**Request for Comments – Cricket NSW Centre of Excellence,
Sydney Olympic Park (SSD-10354)**

I refer to your request for comments on SSD-10354 for the development of Wilson Park for the Cricket NSW Centre of Excellence. SOPA has reviewed the Response to Submissions Report and updated supplementary report prepared by the applicant and has the following comments:

**Tree Management Plan
sheet 1**

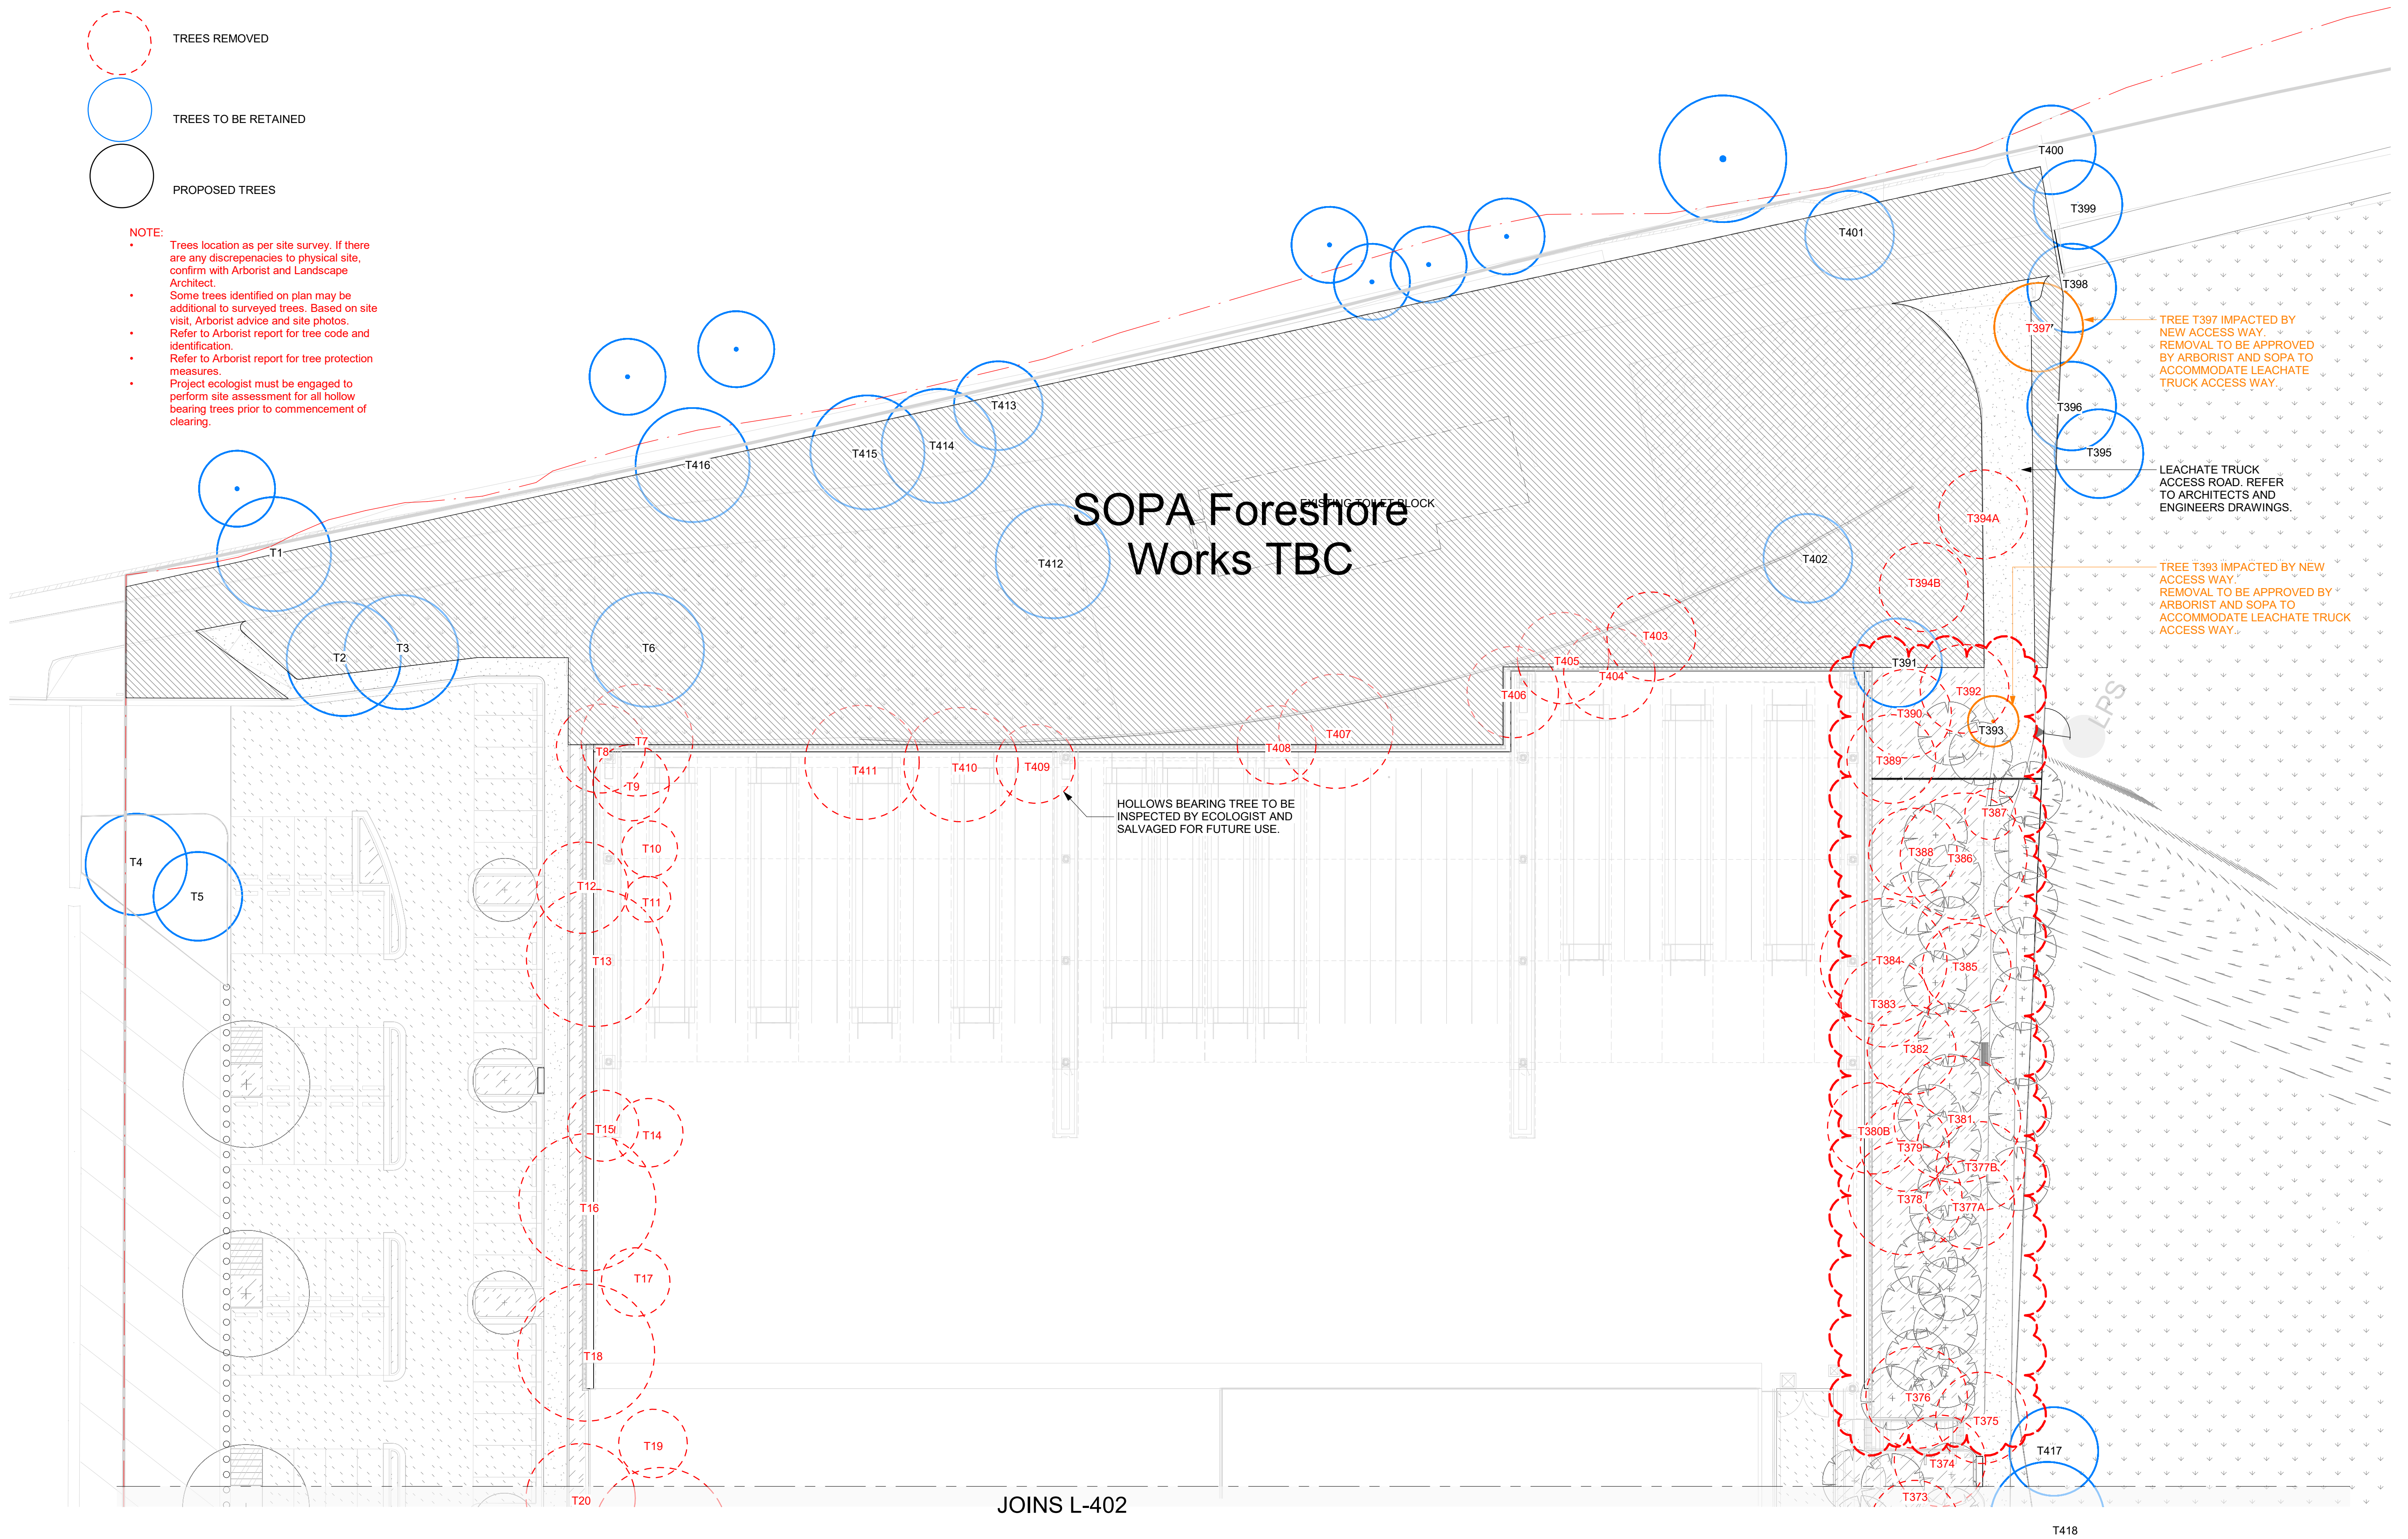
The EIS and revised Landscaping Report identify the removal of 304 trees and replacement planting of 310 trees. There is conflicting information in the Biodiversity Report, which indicates 108 trees will be removed. These documents must be revised so that they are consistent and an accurate assessment of impacts can be undertaken.

The Landscaping Report does not identify the container size of the replacement trees at planting but even in a best-case scenario, they are likely to significantly less mature than the trees they are replacing and result in a loss of tree canopy across the site. This outcome is contrary to the increased canopy targets in the Metropolis of Three Cities and Central City District Plans.

The proposed development should achieve, at minimum, no net loss of tree canopy within 5 years of establishing the replacement planting. This would necessitate either planting more mature tree species as replacement planting or increasing the number of replacement trees.

SOPA supports the comments of the SDRP, dated 7 April 2020, which recommend the retention of existing vegetation around the edges of the site.

To ensure suitable replacement planting arrangements, SOPA request a condition of consent be imposed requiring that the detailed landscape plan, including planting schedule, be approved by SOPA's Director, Environment and Planning prior to the issue of the relevant Construction Certificate.
